## REQUEST

Current Zoning: I-1(CD) (light industrial, conditional)  
Proposed Zoning: UR-2(CD) (urban residential, conditional)

The petition proposes to develop the vacant site southwest of the Sterling neighborhood with a residential community with up to 186 single family attached units and is Phase 5 of the Blu South development north of the site.

Staff recommends approval of this petition upon resolution of outstanding issues and technical revisions related to transportation, site and building design and stormwater.

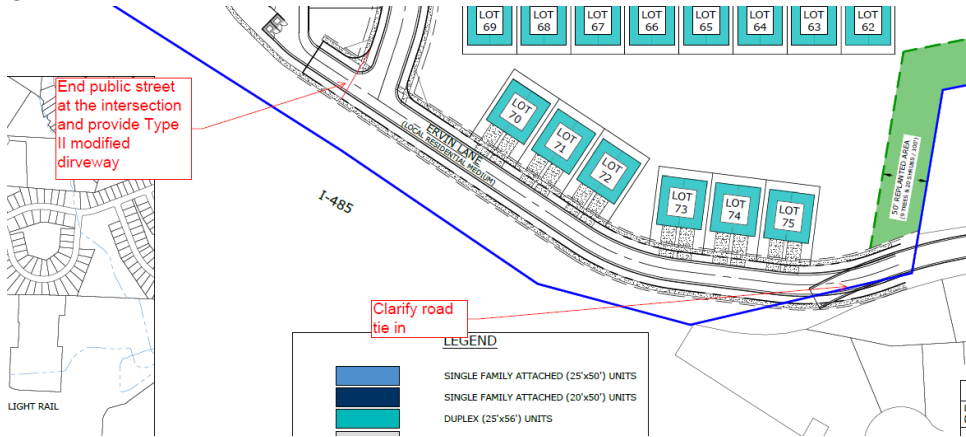
4. Complete a CTR (comprehensive transportation review) for the site. Review and assess the public accessible pedestrian network within ¼ mile walking distance of the site to identify multimodal infrastructure to meet the Tier 2 (6 mitigation points) for multimodal assessment.

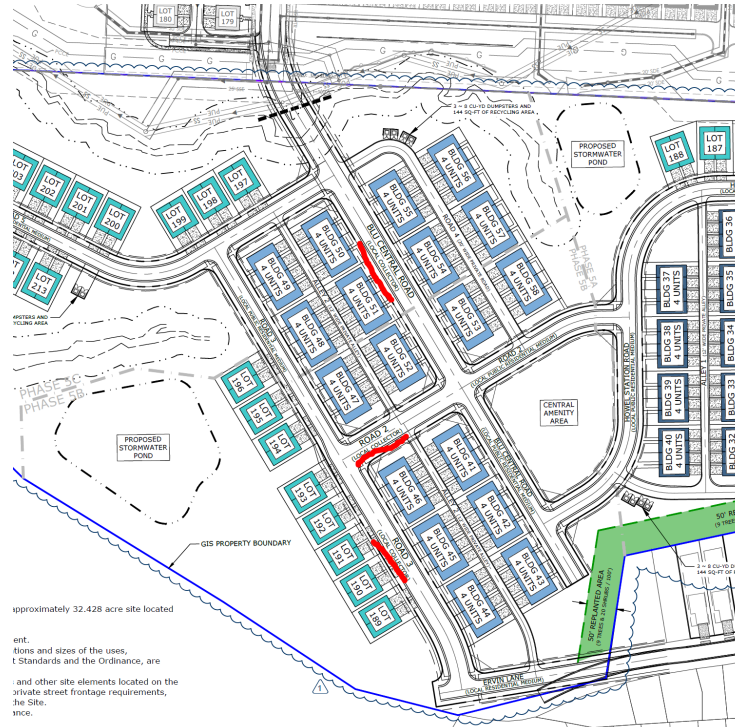
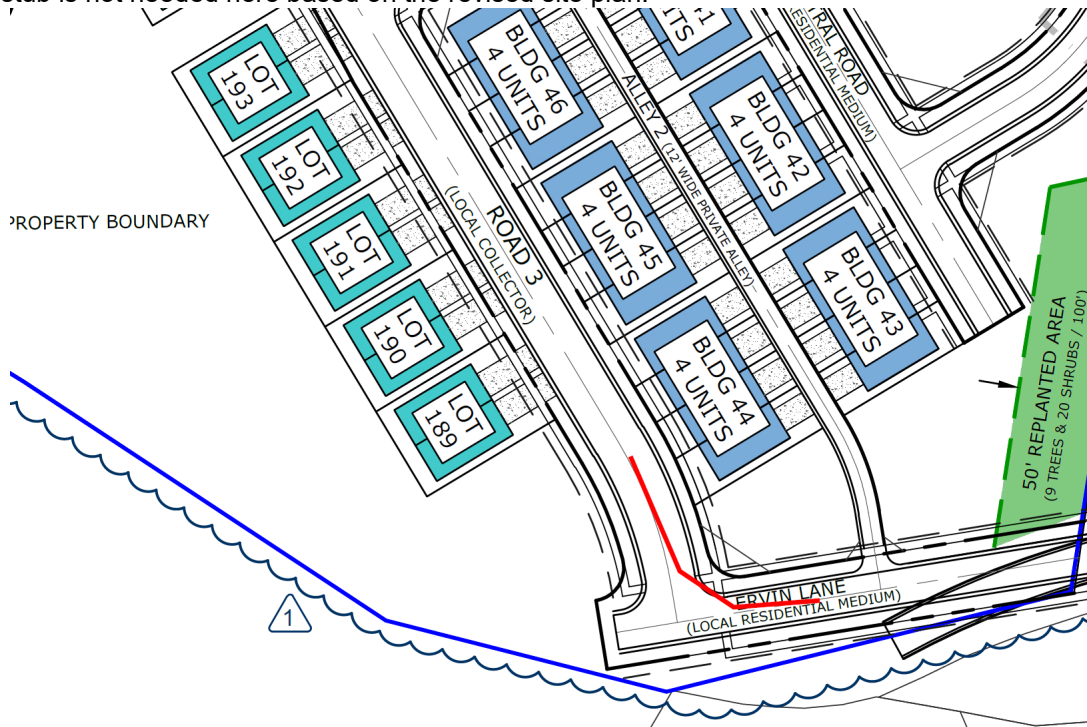
7. Amend the site plan to provide a single continuous street from Blu Central Rd. to Ervin Ln. that meets CDOT design standards.
